From: Amanda Scholes on behalf of Planning.Responses
Sent: 26 March 2021 10:30
To: Planning Scanning
Subject: FW: LU/45/21/DOC - Cornfield Close

From: Katie Gilbert [REDACTED]
Sent: 26 March 2021 07:56
To: Anita Gardner <Anita.Gardner@arun.gov.uk>
Subject: RE: LU/45/21/DOC - Cornfield Close

In relation to the Verification Report (ref.: GE18103/VR/JAN21, dated January 2021) submitted in relation to the above, whilst the majority of the report seems satisfactory, there are some discrepancies which will please need to be clarified before EH can provide a complete response. For ease, these queries are detailed below:

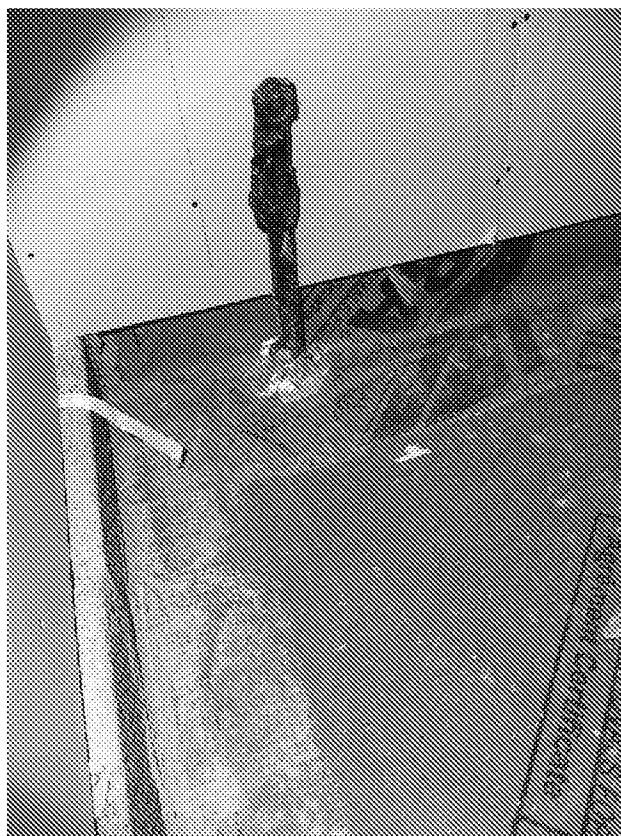
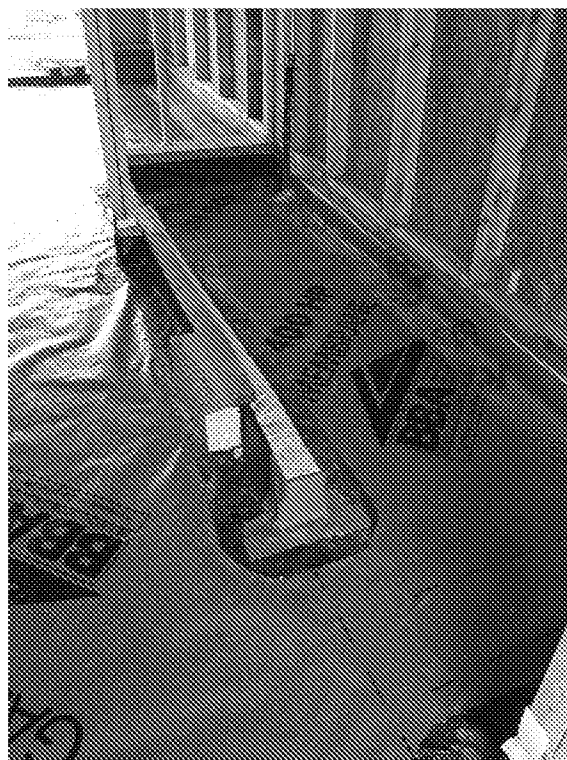
- are the consultants satisfied with the gas protection measures installed? It is understood that Plots 11, 14 and 15 were incomplete at the point of publication, although photographs of the subsequent completion were provided by the applicant's representative.

- are the consultants satisfied with the gas protection measures installed? It is understood that Plots 11, 14 and 15 were incomplete at the point of publication, although photographs of the subsequent completion were provided by the applicant's representative. Geo-Environmental are satisfied with the membranes at the point of inspection and in relation to the additional photographs provided.
- ref to sampling by Bell – I'm not sure what this comment relates to?
